Application for a non-material amendment following a grant of planning permission.

<input type="text" value="Erection of one detached 2 -Bedroom Bungalow"/>	
Reference number:	<input type="text" value="20/01514/FUL"/>
Date of decision	<input type="text" value="01/06/2021"/>

2132-WR03 Rev A proposed plans  
2132-WR04 Rev B proposed elevations

Rev	Description	Date
Address: LAND REAR OF 38 WOODLANDS ROAD EPSOM, KT18 7HW		
Drawing Title: PROPOSED ELEVATIONS		
Scale: 1:100 @A3	Drawing Number	Rev
Date: JAN 2022	2132-WR04	A

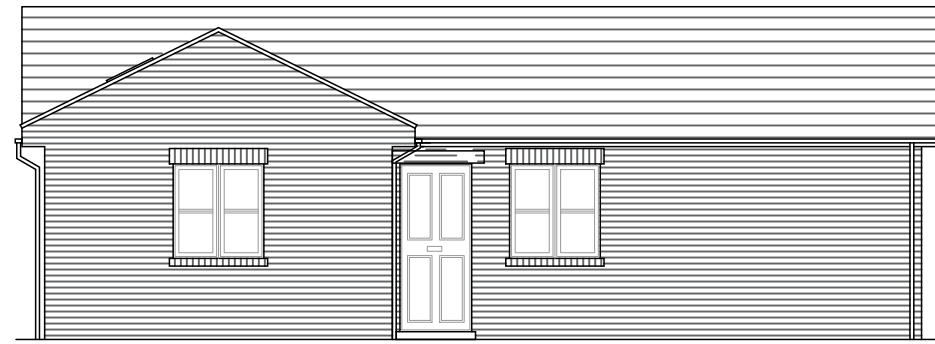
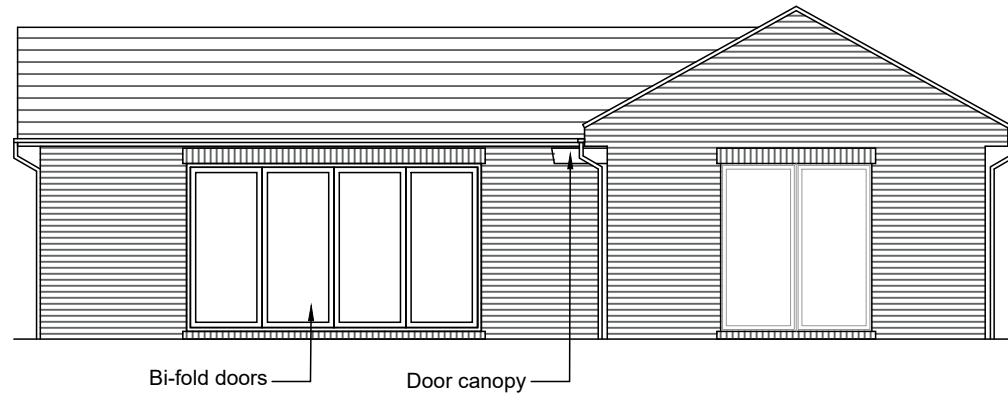
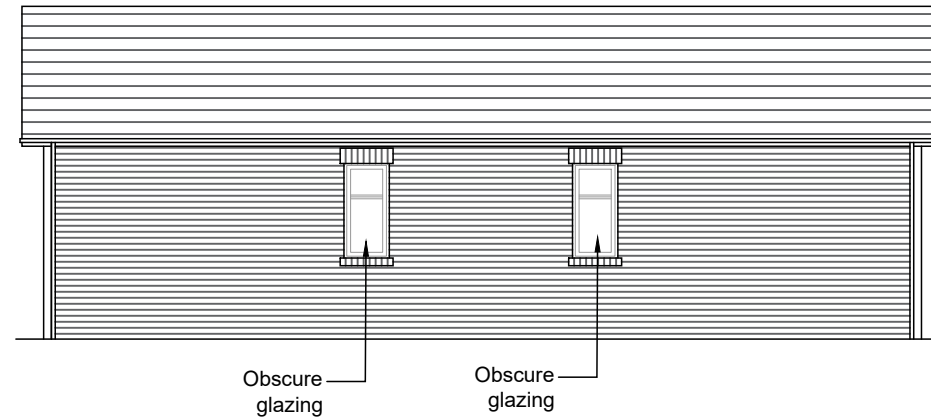
- 1) Kept only one entrance instead 2
- 2) Widen the patio door
- 3) Few window positions changed
- 4) 2 new roof windows (velux) windows added.
- 5) Internal layout changed

The main reason for this application is to create a better layout internally and instead of 2 entrance doors to keep only one entrance door.
